WEST SUSSEX COUNTY COUNCIL CONSULTATION

TO:	Arun District Council FAO: Simon Davis
FROM:	WSCC - Highways Authority
DATE:	31 March 2020
LOCATION:	The Beach Hotel, former Mud Club & 2-4 Waterloo Square Bognor Regis PO21 1SU
SUBJECT:	BR/282/19 Redevelopment into 49 No apartments consisting of 24 No 1 & 25 No 2 bed apartments & 2 No commercial units (A3 Restaurant & Cafe). This application affects the character & appearance of The Steyne, Bognor Regis Conservation Area & may affect the setting of a listed building.
DATE OF SITE VISIT:	29 March 2020
RECOMMENDATION:	Modification

Drawing No.	Rev.
2020-6153-001	A

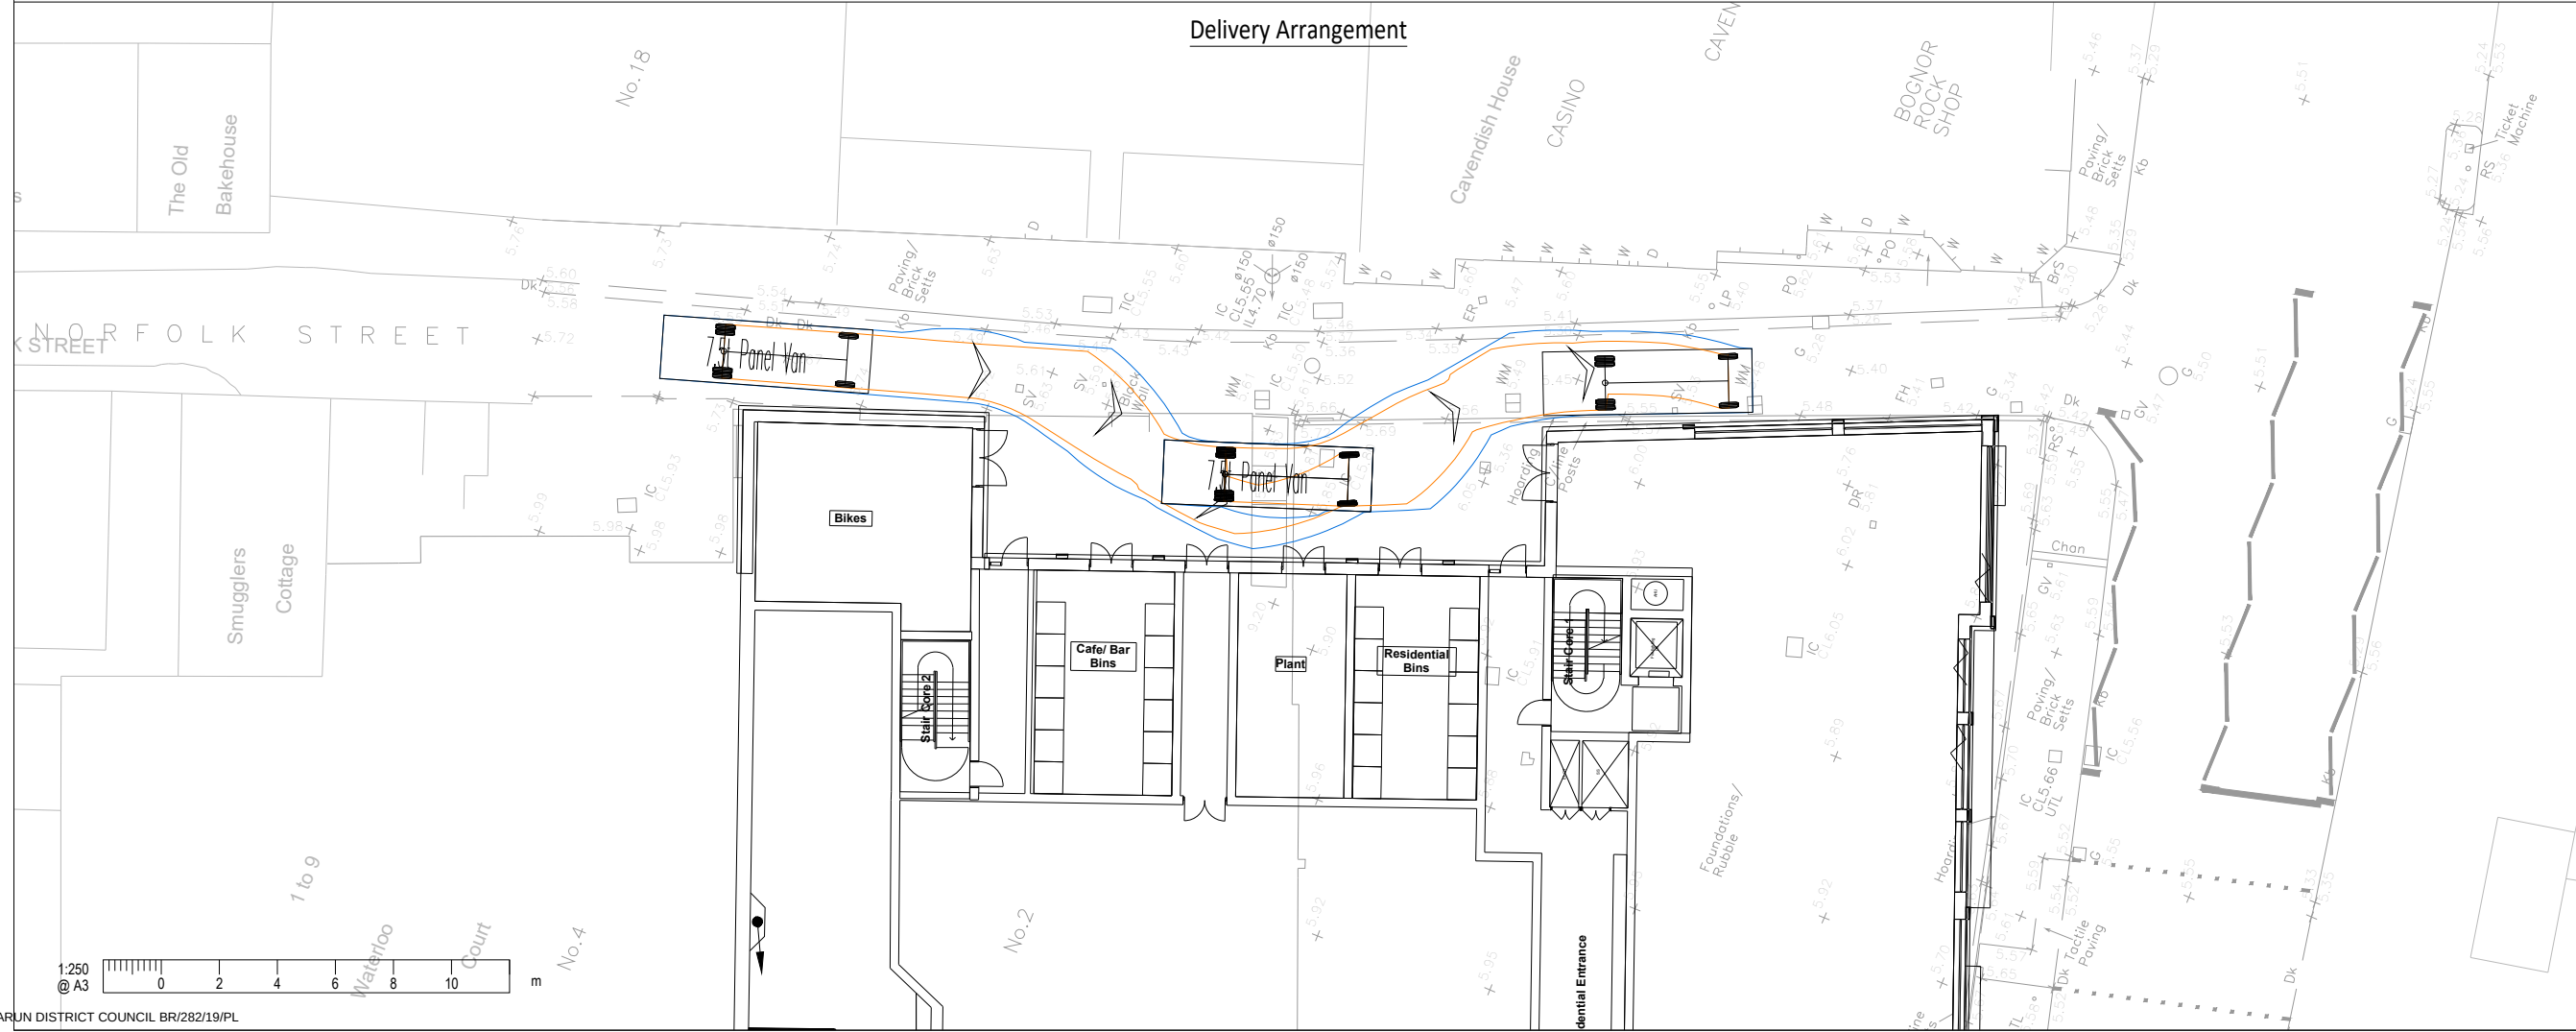
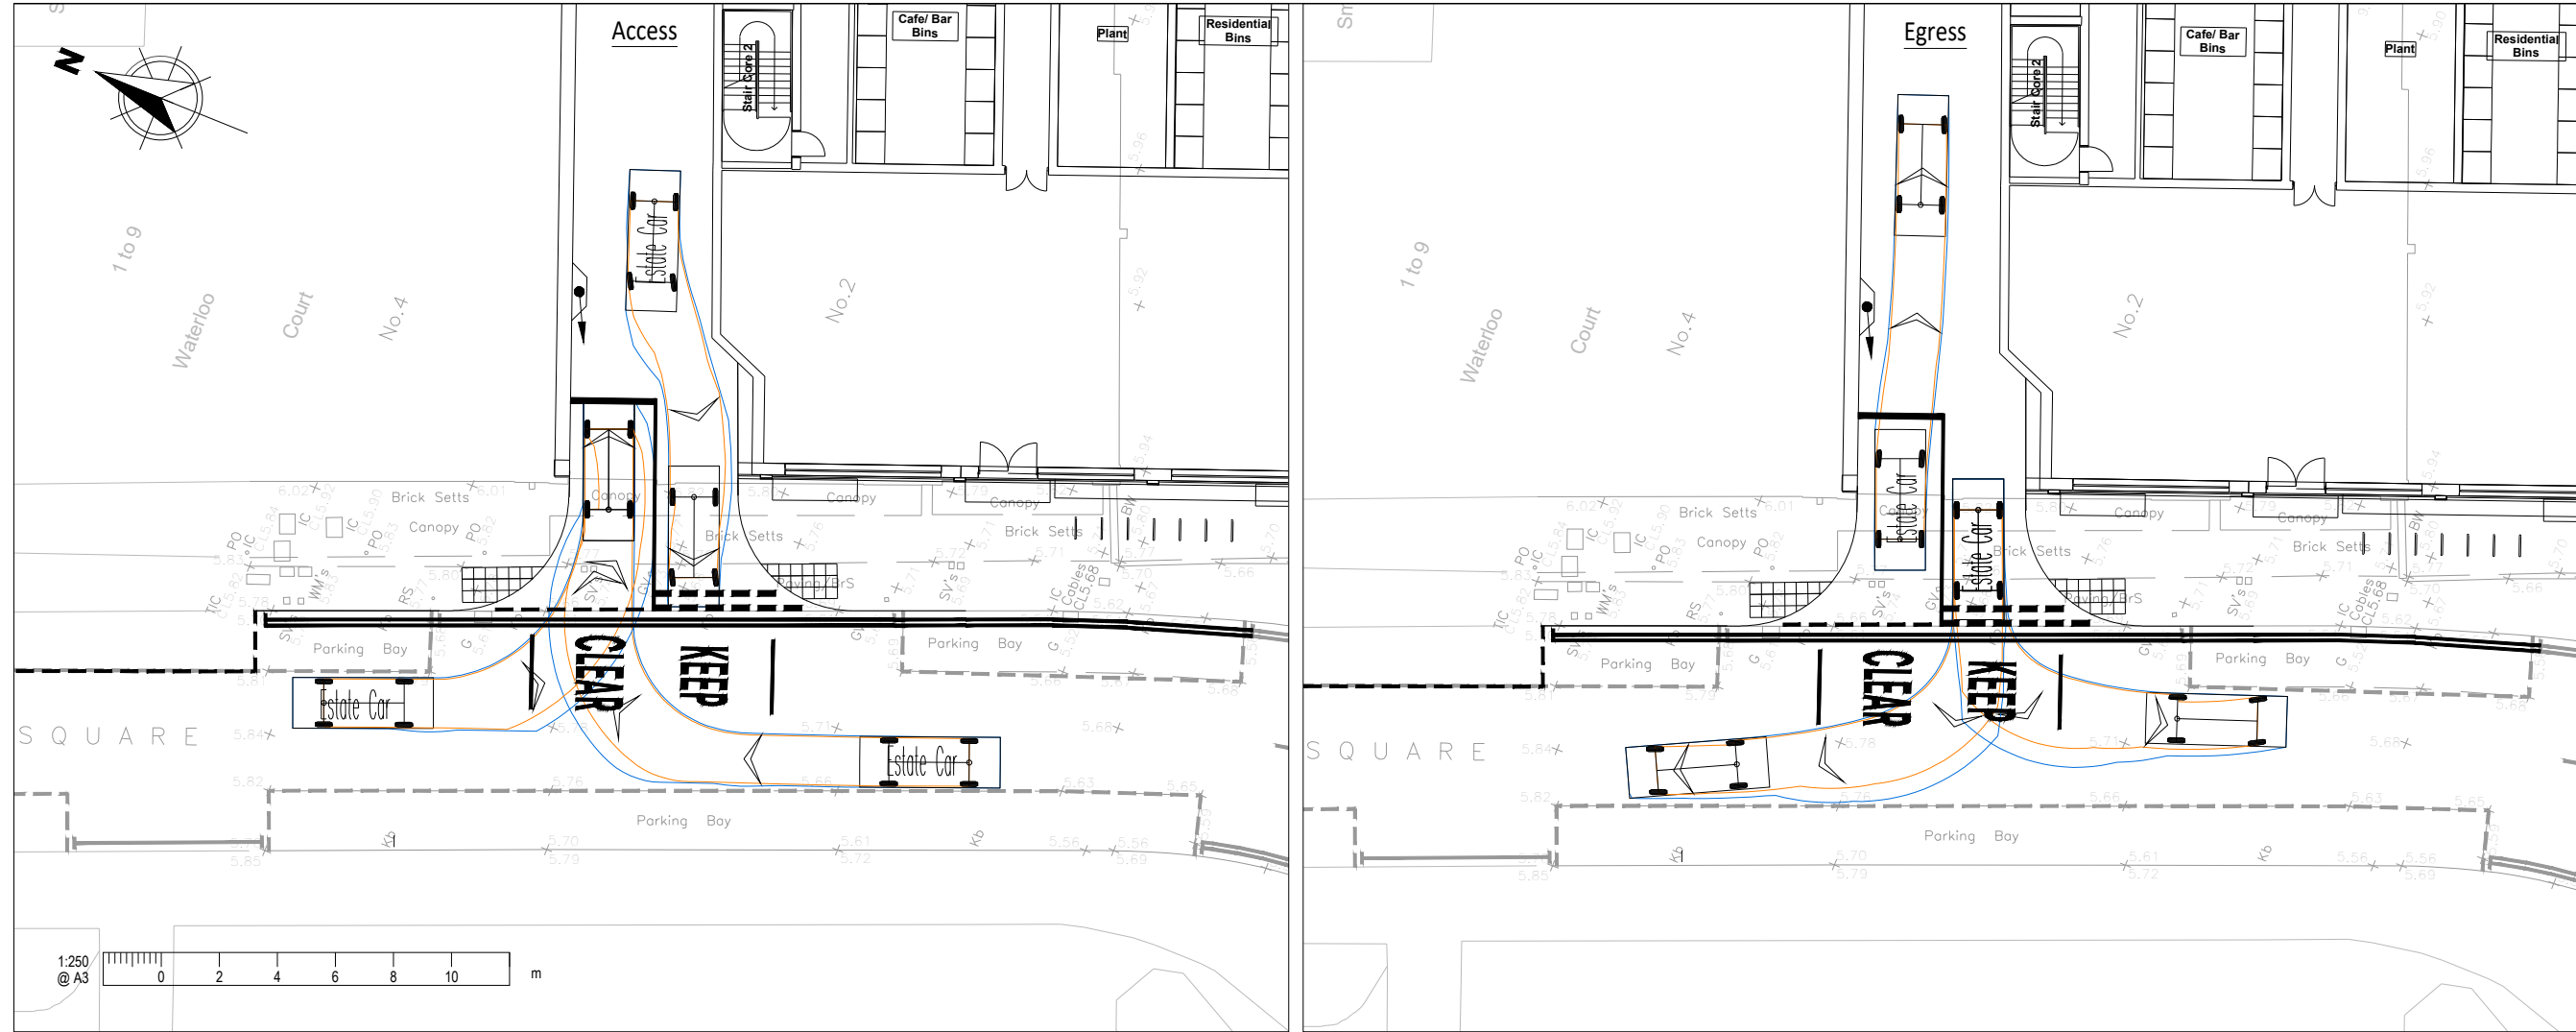
Drawing no. 2020-6153-001 Rev A demonstrates vehicular visibility splays of 2.4m by 43m. This is suitable Stopping Sight Distance (SSD) for new accesses where 30mph

The northern splay utilises the width of the existing footway and is not obscured by on-street parking. The southern splay extends to the junction and crosses a small section of the on-street parking bays. The splay has also been drawn to an offset from the centre-line to represent where the driver would be present (with it not anticipated that a car would be travelling in the opposing lane at the junction). MfS2 expands on visibility splays where on-street parking is present by stating that *"Vehicle exits at the back edge of the footway mean that emerging drivers will have to take account of people on the footway. The absence of wide visibility splays at minor accesses will encourage drivers to emerge more cautiously - similarly to how vehicles pull out when visibility along the carriageway is restricted"* (paragraph 10.6.1). The LHA considers that MfS is applicable in this instance and that it would be appropriate in this location for a car to edge forward considering the anticipated low speeds, presence of similar accesses and suitable forward visibility along Waterloo Square.

It is also considered that due to the set back of the proposed building that some level of visibility of pedestrians will be available either side of the access, upon a car exiting. Comparing the extent of highway boundary mapping to the red edge plan of the site, it would appear that there is a strip of land not public footway and not within the red edge of the site. A small section of this land immediately south of the proposed access could be kept clear to allow for improved visibility of pedestrians on the adjacent footway. The applicant could also propose to put this strip of hardstanding forward for adoption under a S38 agreement. The applicant is invited to clarify this point.
